**Re: State Significant Development – SSD-10391 Mod 2 – New Liverpool Primary School  
18 Forbes Street Liverpool NSW 2170**

## **Comments on the new Liverpool Primary School – 18 Forbes Street, Liverpool**

3
SIDE ENTRY DROP OFF ZONE SIGNAGE
SCHOOL NAME + LOGO
BRUSHED CHARCOAL METAL FINISH
APPROX 4500 x 1200

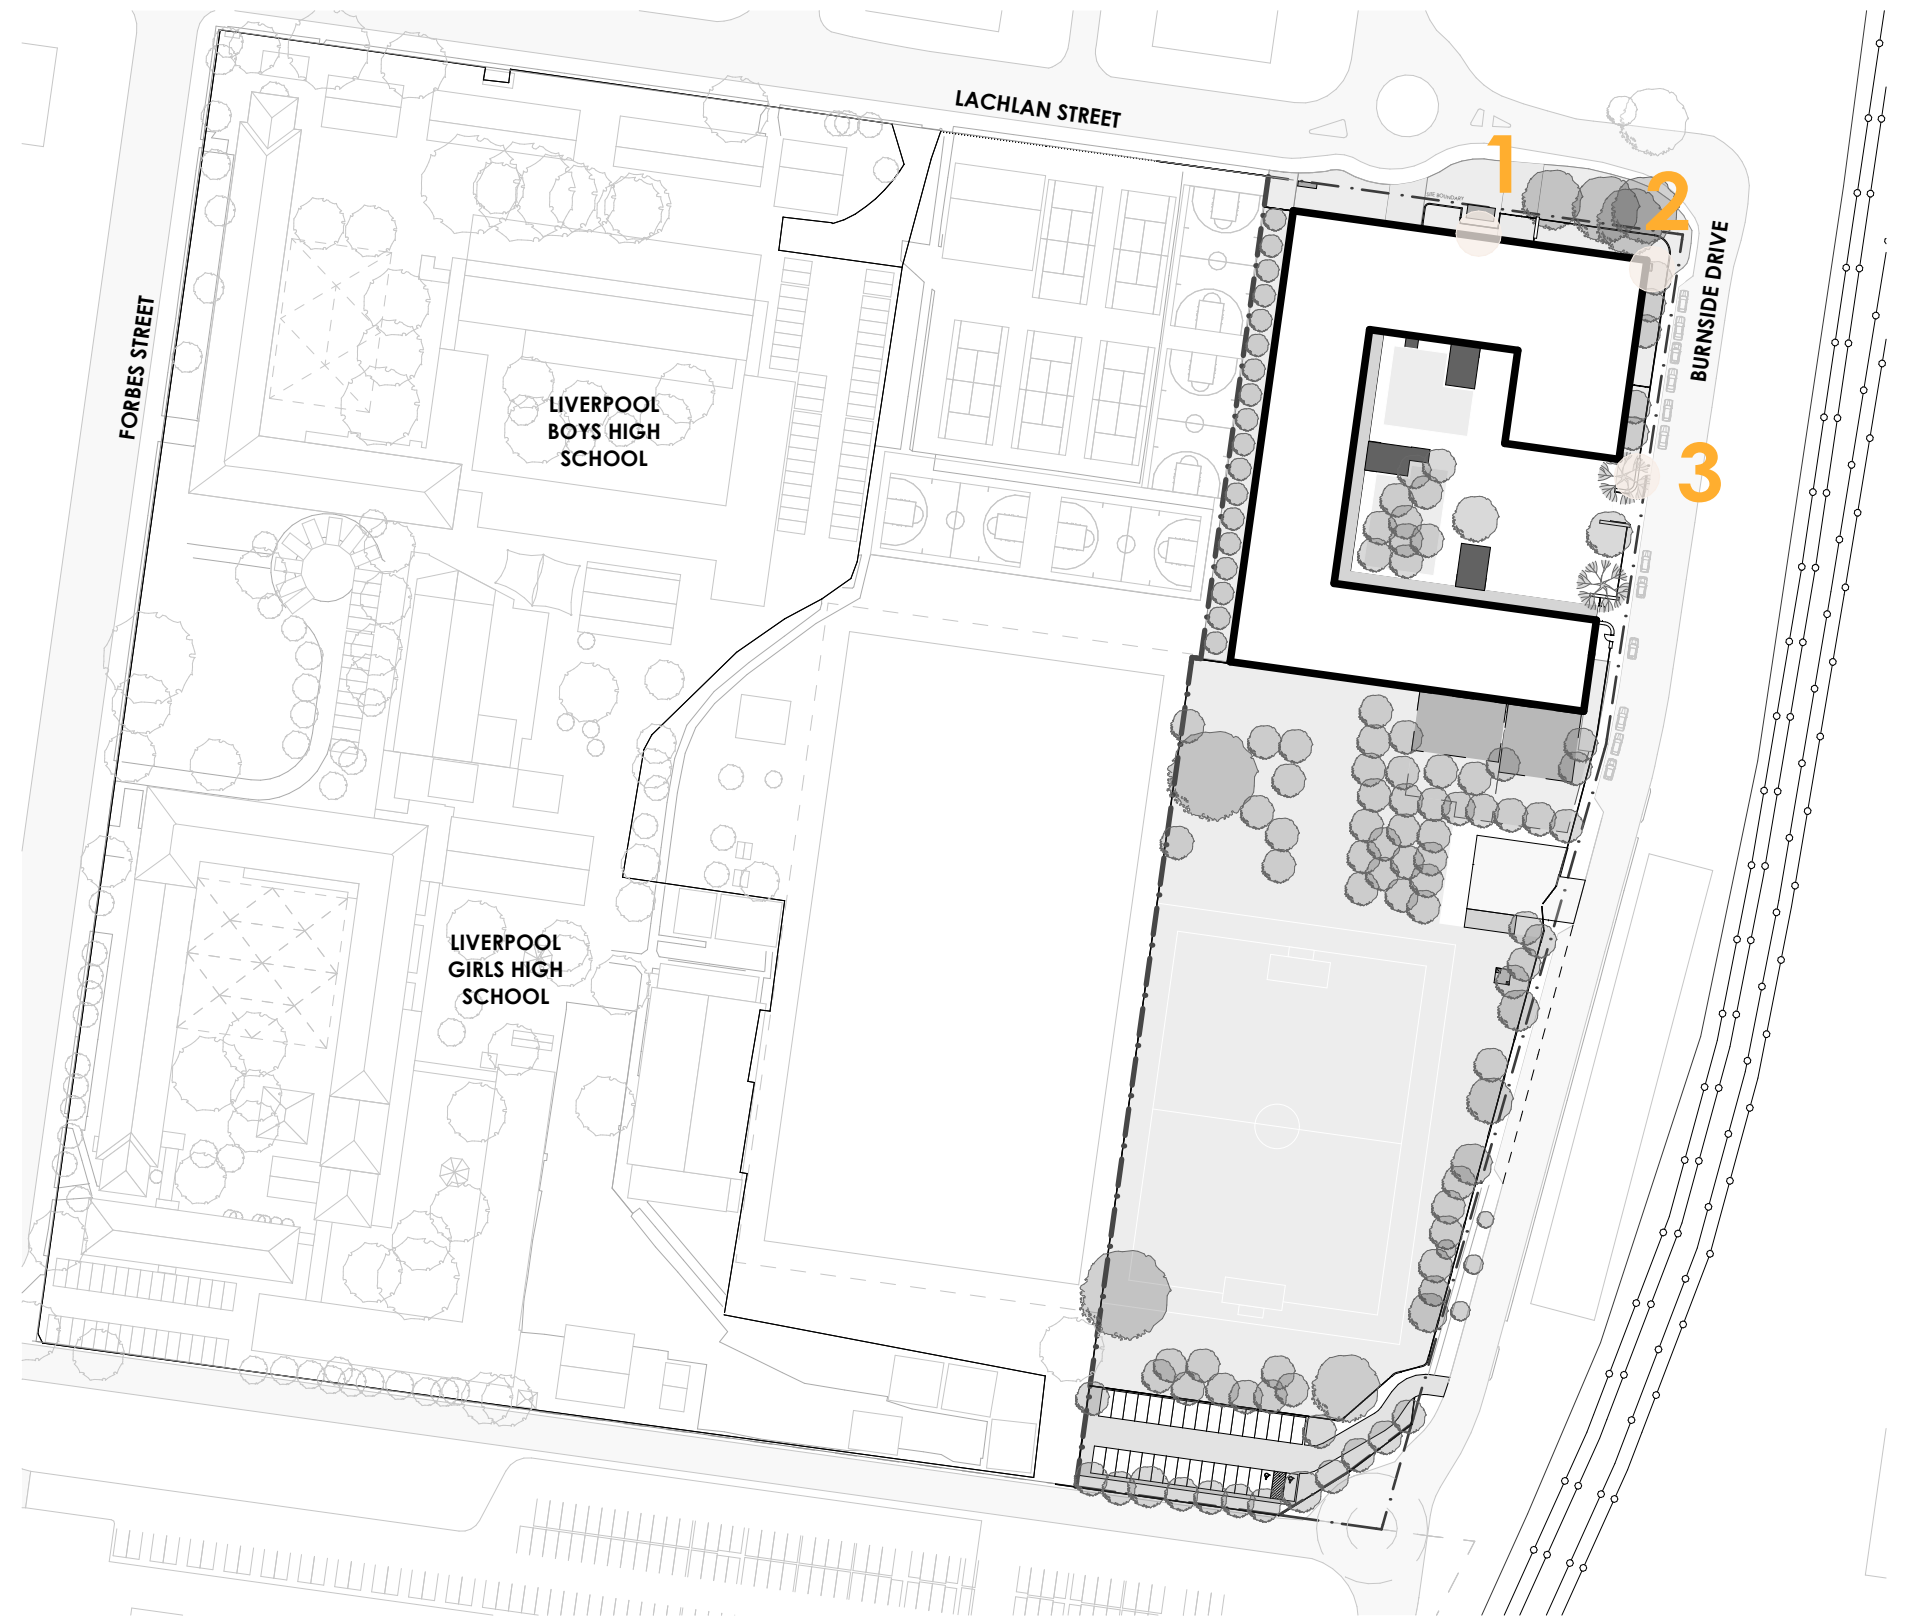
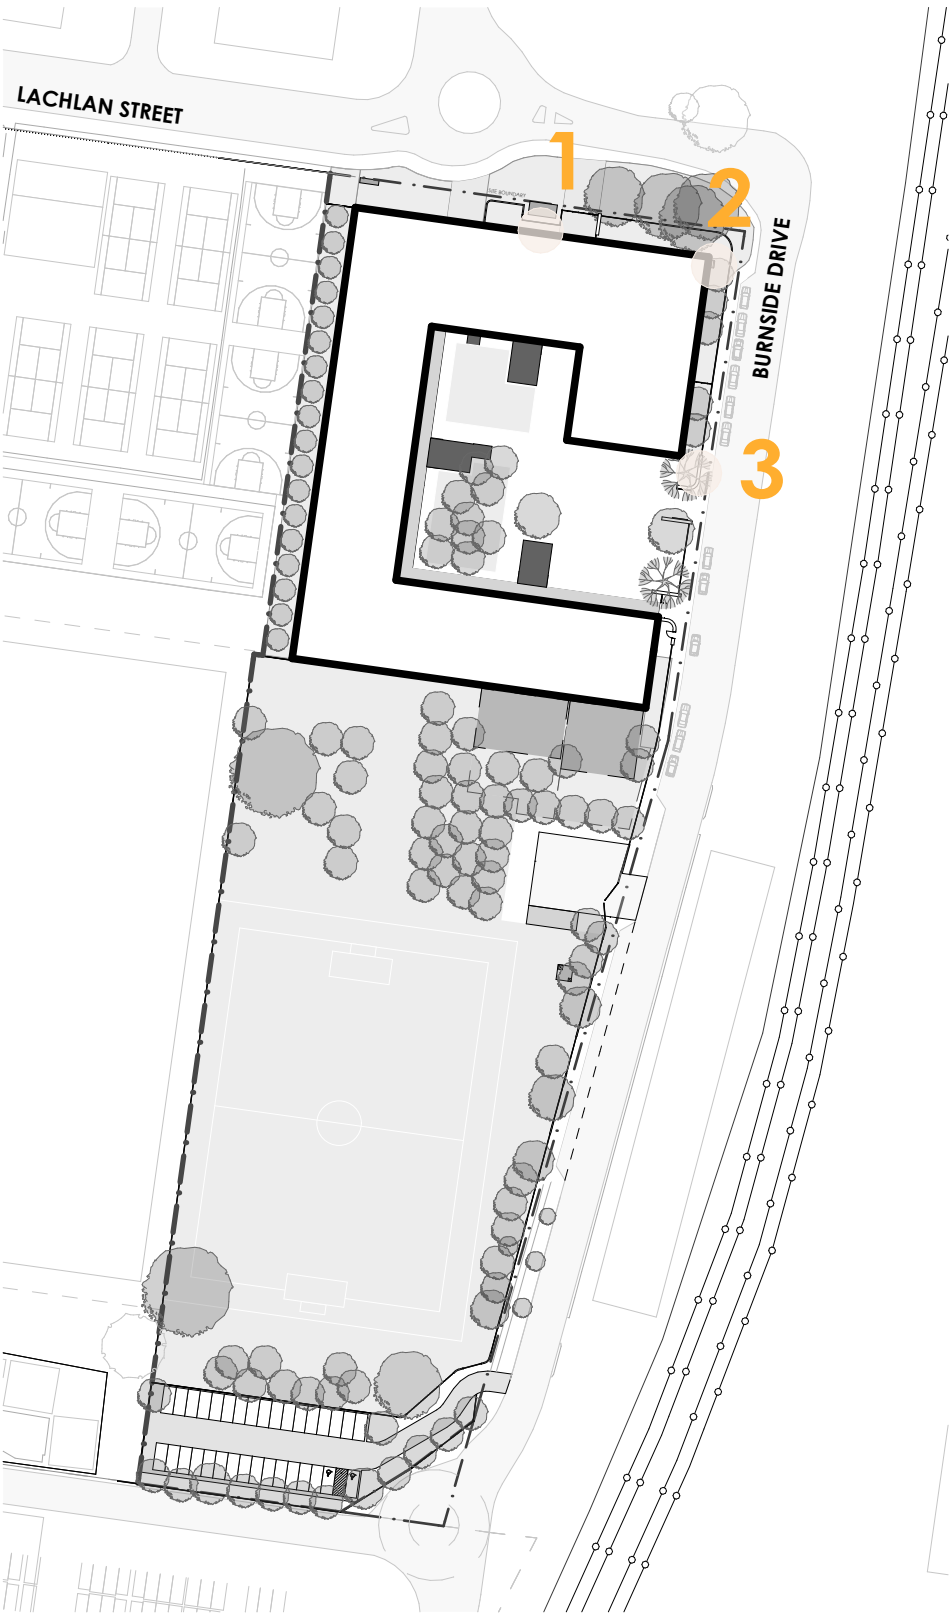
Council has concern the new digital signage will prevent direct access to the school from Lachlan Street. The applicant should submit perspective highlighting the positioning of proposed signage, including perspectives of frontages of the school from the public domain.

GROUND PLAN: ACCESS AND CIRCULATION

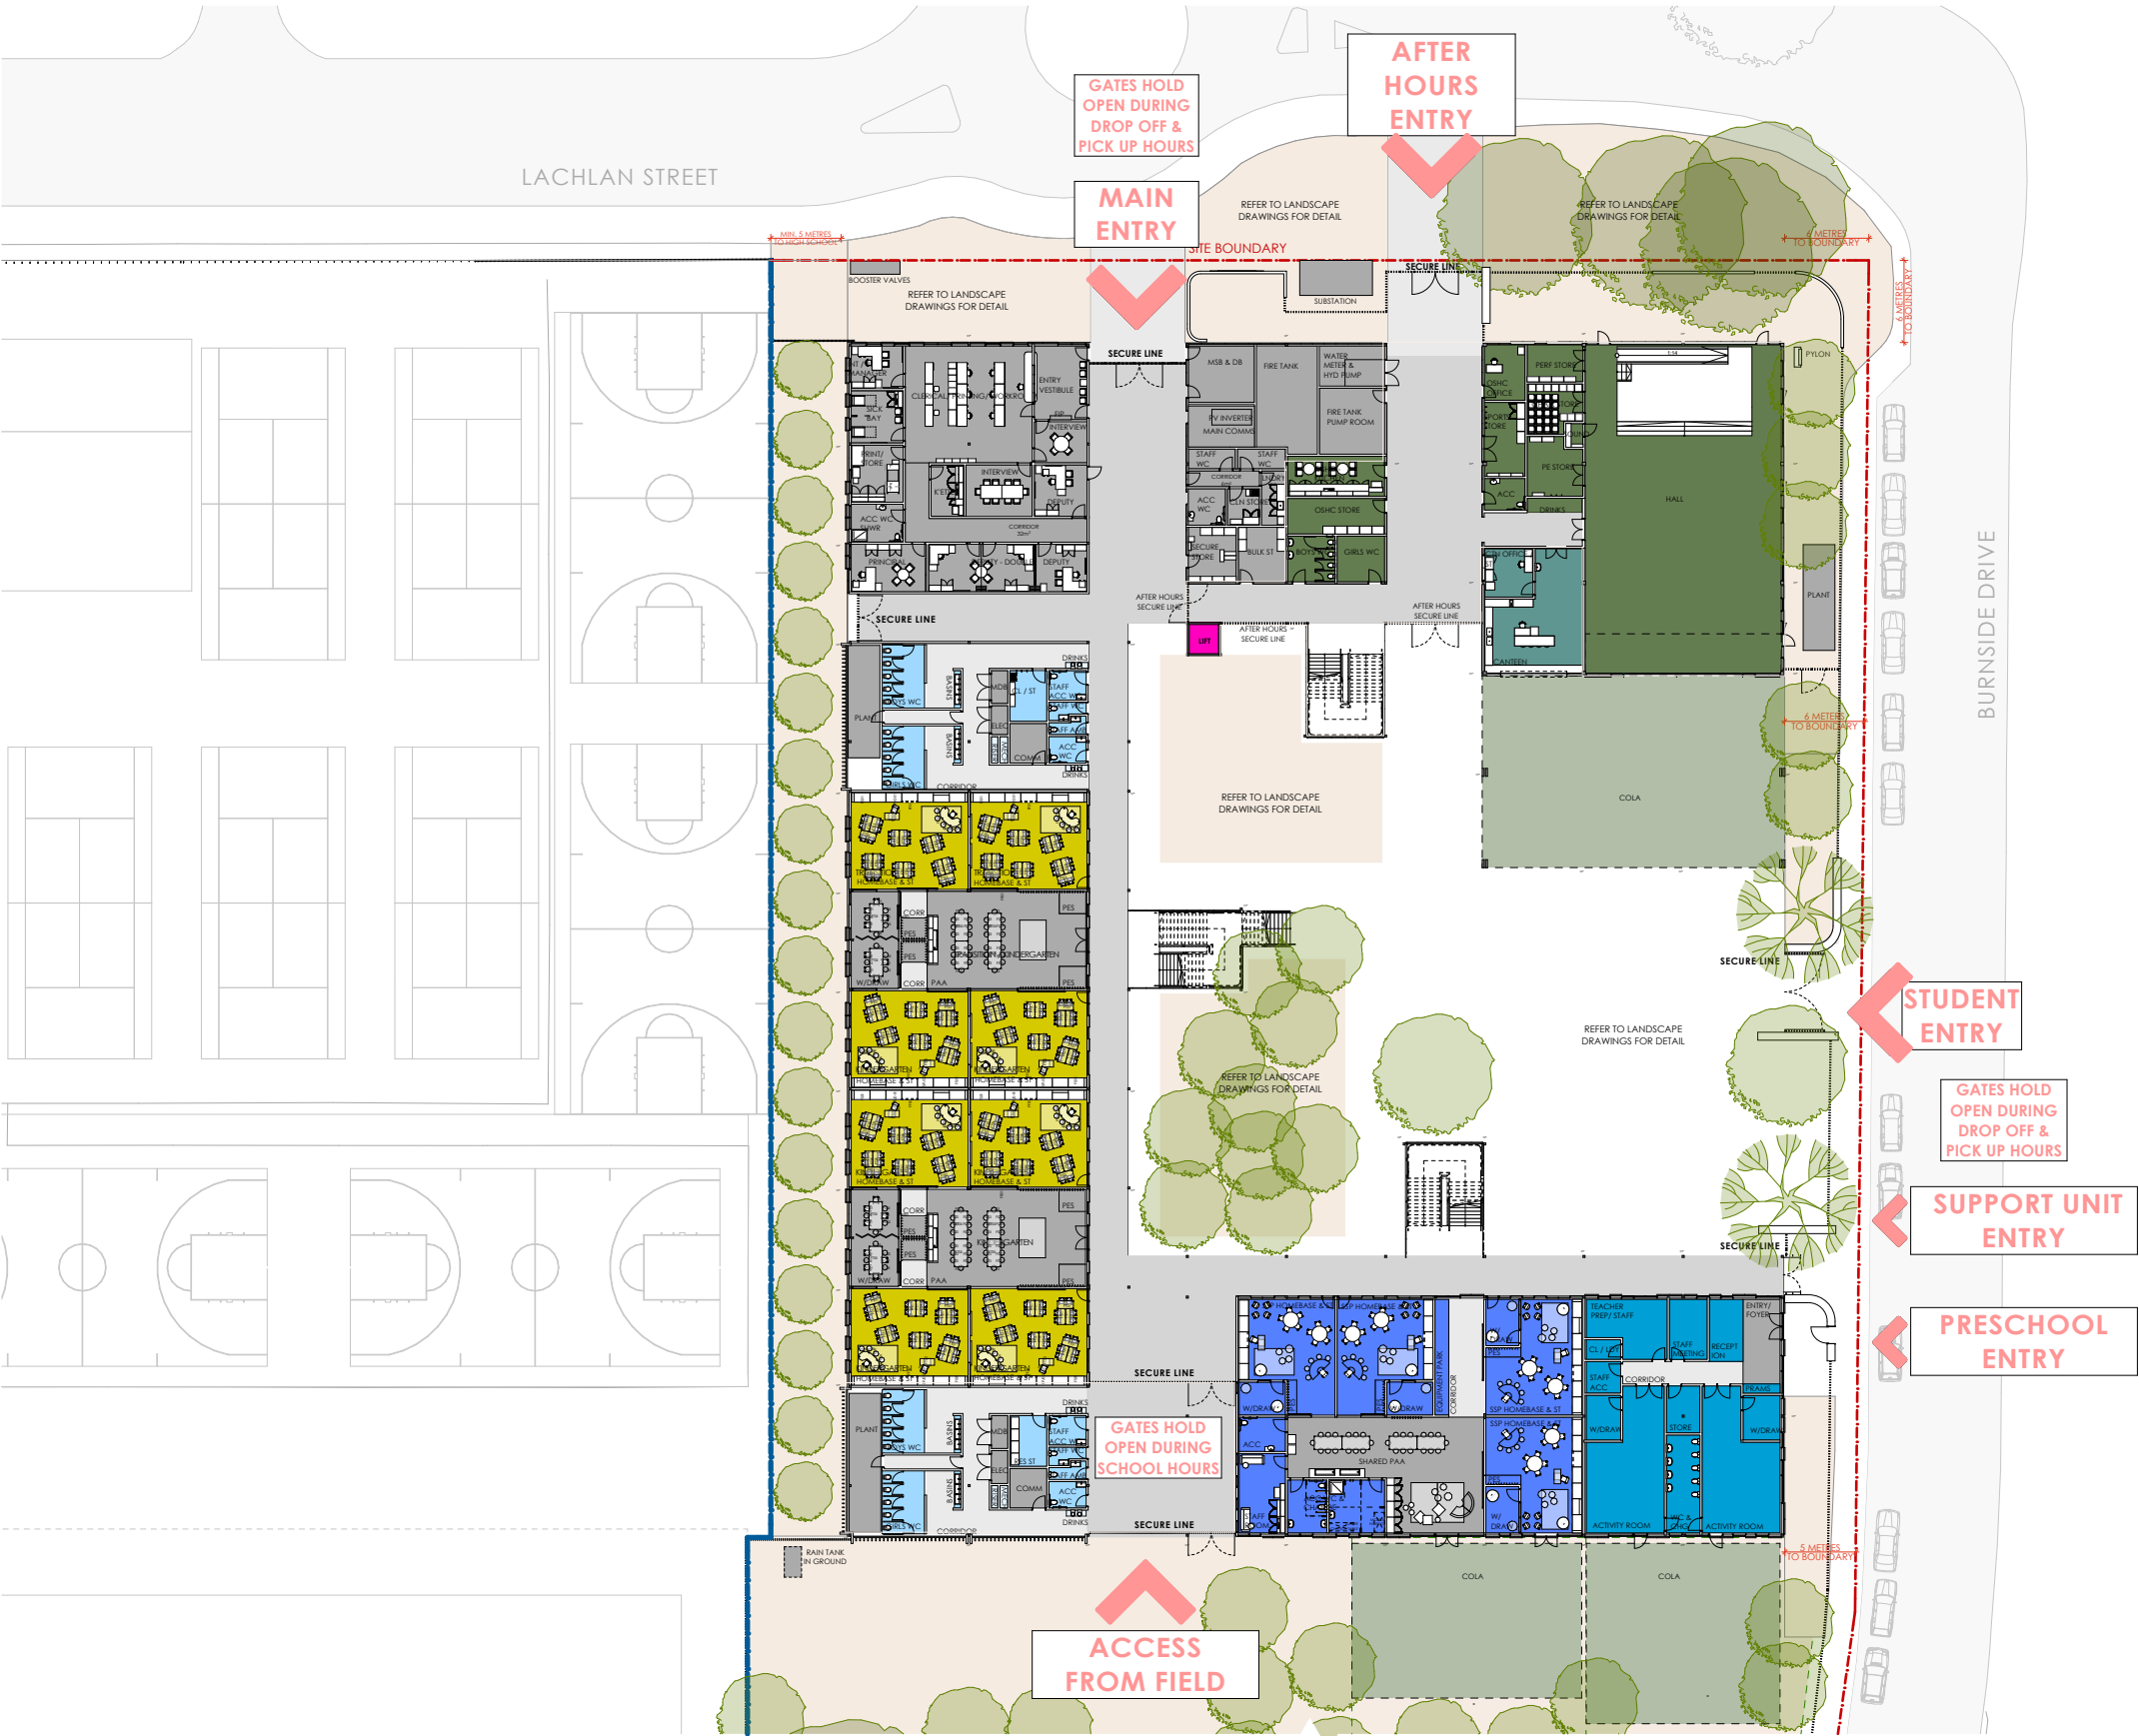
There is concern the location of the bicycle parking is inaccessible to cyclists. The relocation of the road will place the bicycle parking along the new internal road which only supports vehicles. Further consideration should be given to how cyclists are able to access bicycle parking from the public domain.

Consideration should be given to providing a protected cycle path or consider moving the bicycle parking closer to the Lachlan Street entrance.

Figure 1.23: New Liverpool PS Walking Catchments

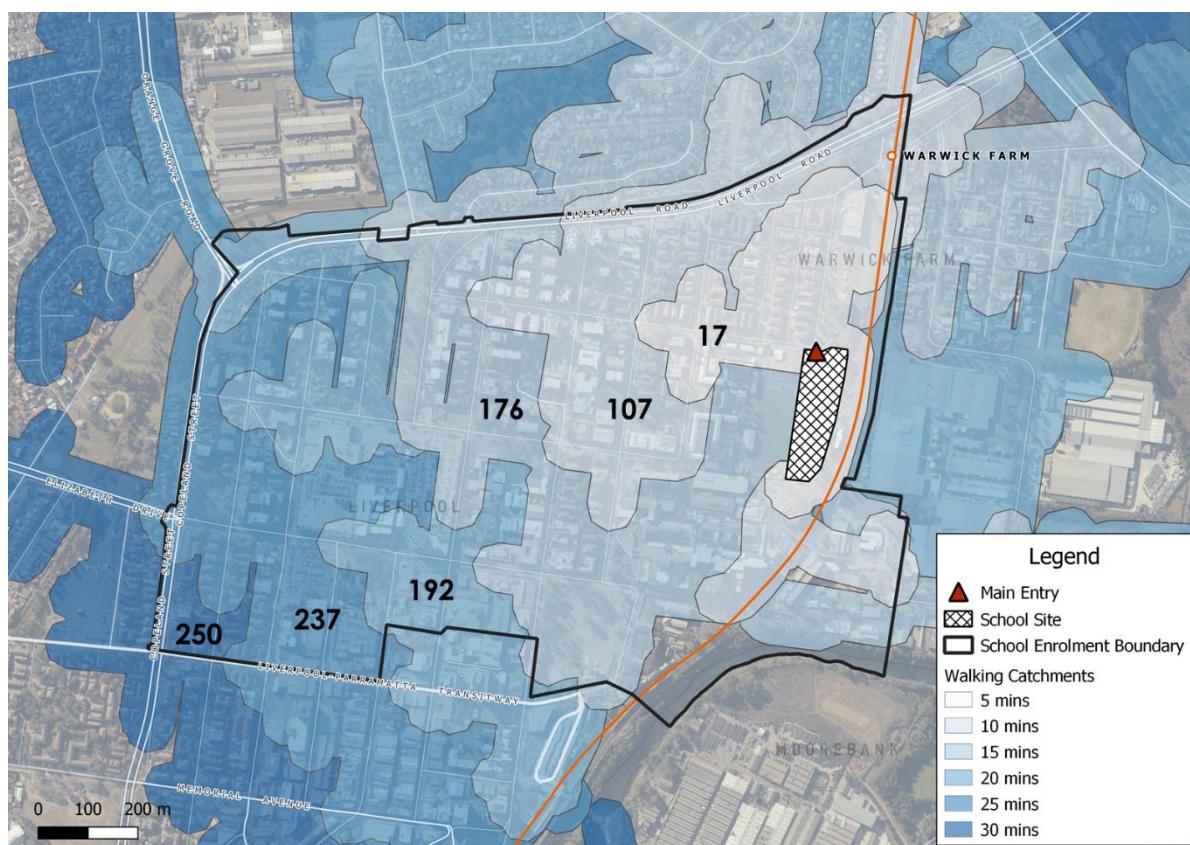
- A catchment map of the proposed intake area is to be included in the revised TIA report.
